54 St. John St.

Site Plan

Barber foods

RE: Barber Foods Expansion

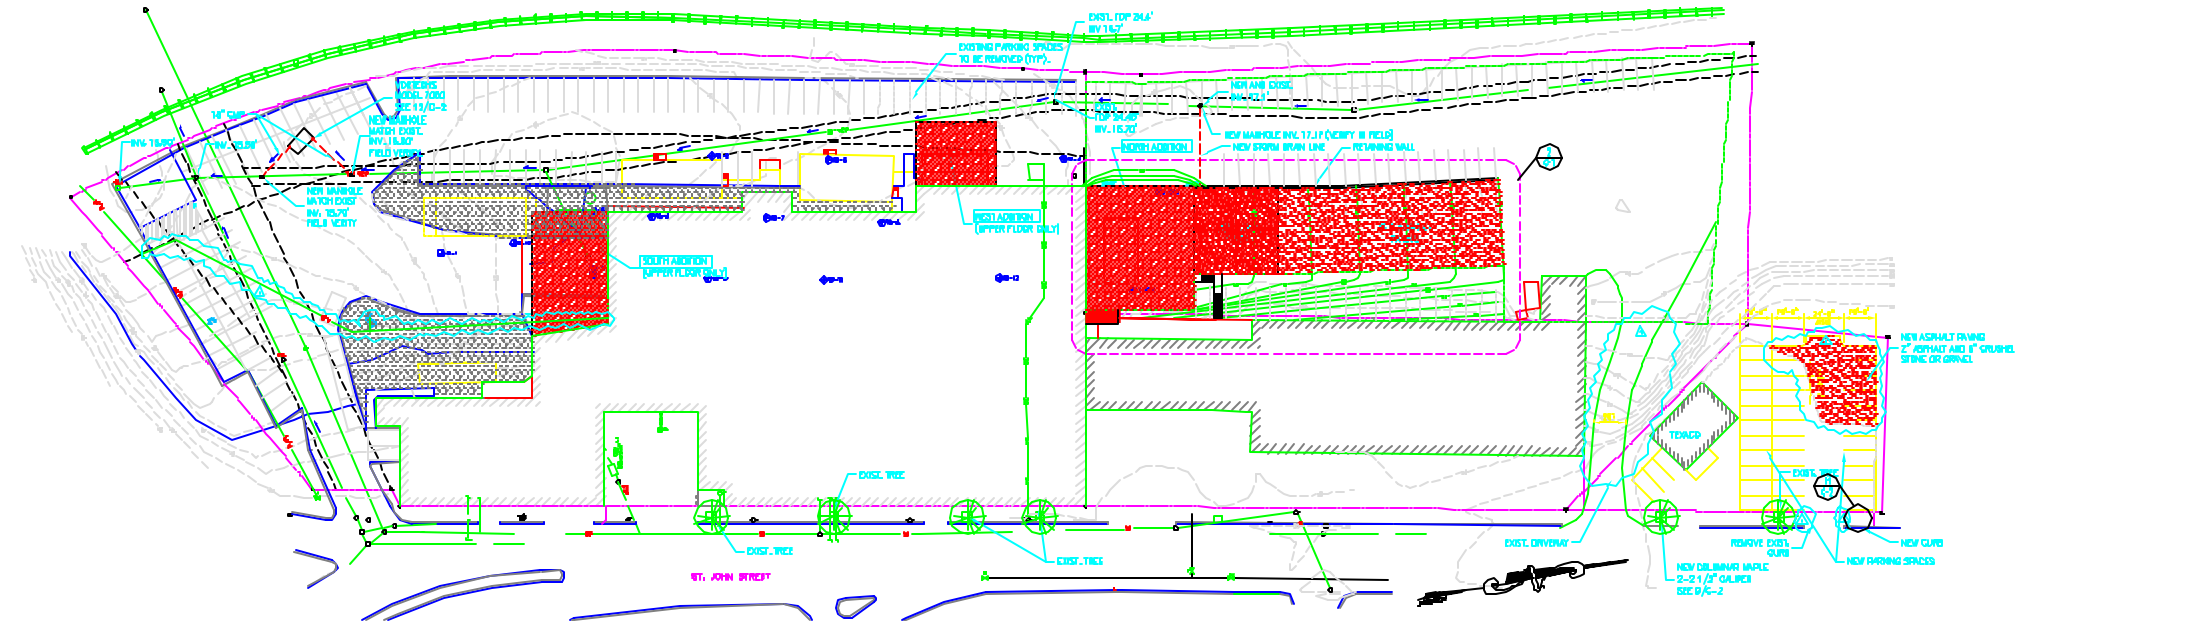
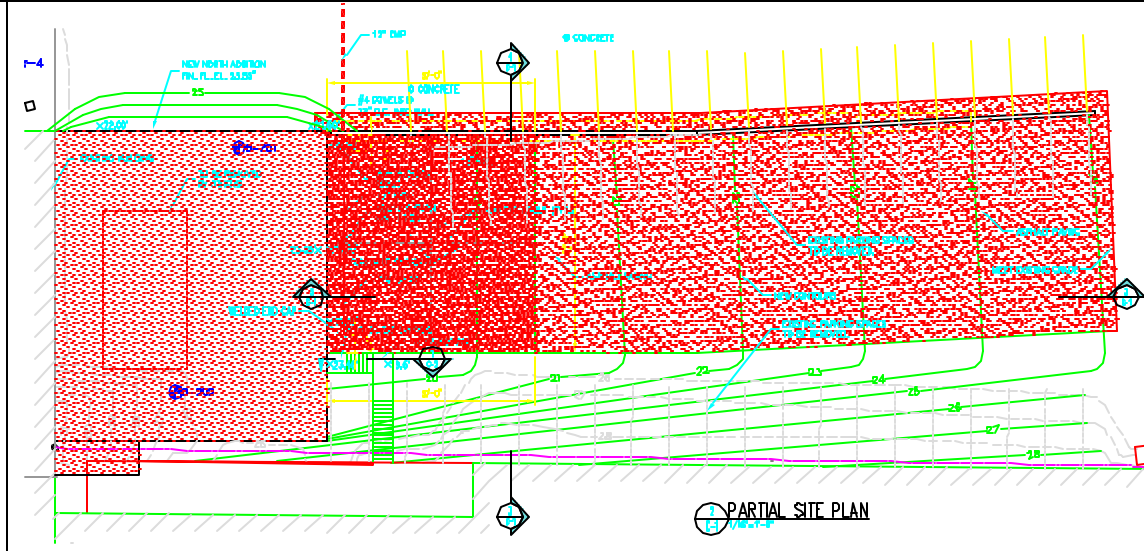
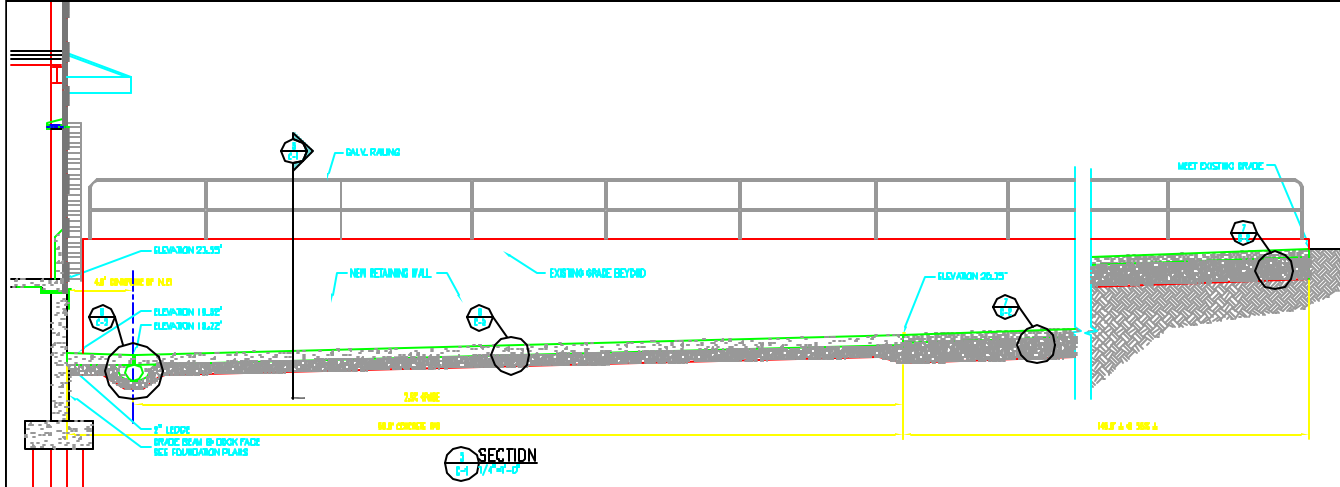
1. The plans remain incomplete as to the design for grading, drainage, lighting and other measures for the parking on the Texaco lot. The applicant should provide revised plans showing these details. You will note that the proposed parking on the texaco lot is very close to the property line and grading etc may be problematic. Without any contours etc. on the plan it is difficult to tell.

2. The plans should be revised to include the appropriate grading of the access drive from the new loading area to St. John st. next to Century Tire. The current plan grading is incorrect or misdrawn.

4. I remain concerned that there is not adequate maneuvering area near the west addition for semitrailer trucks to pass if cars are parked in the current plan formation. Has The fire Dept. signed off for emergency vehicle access?
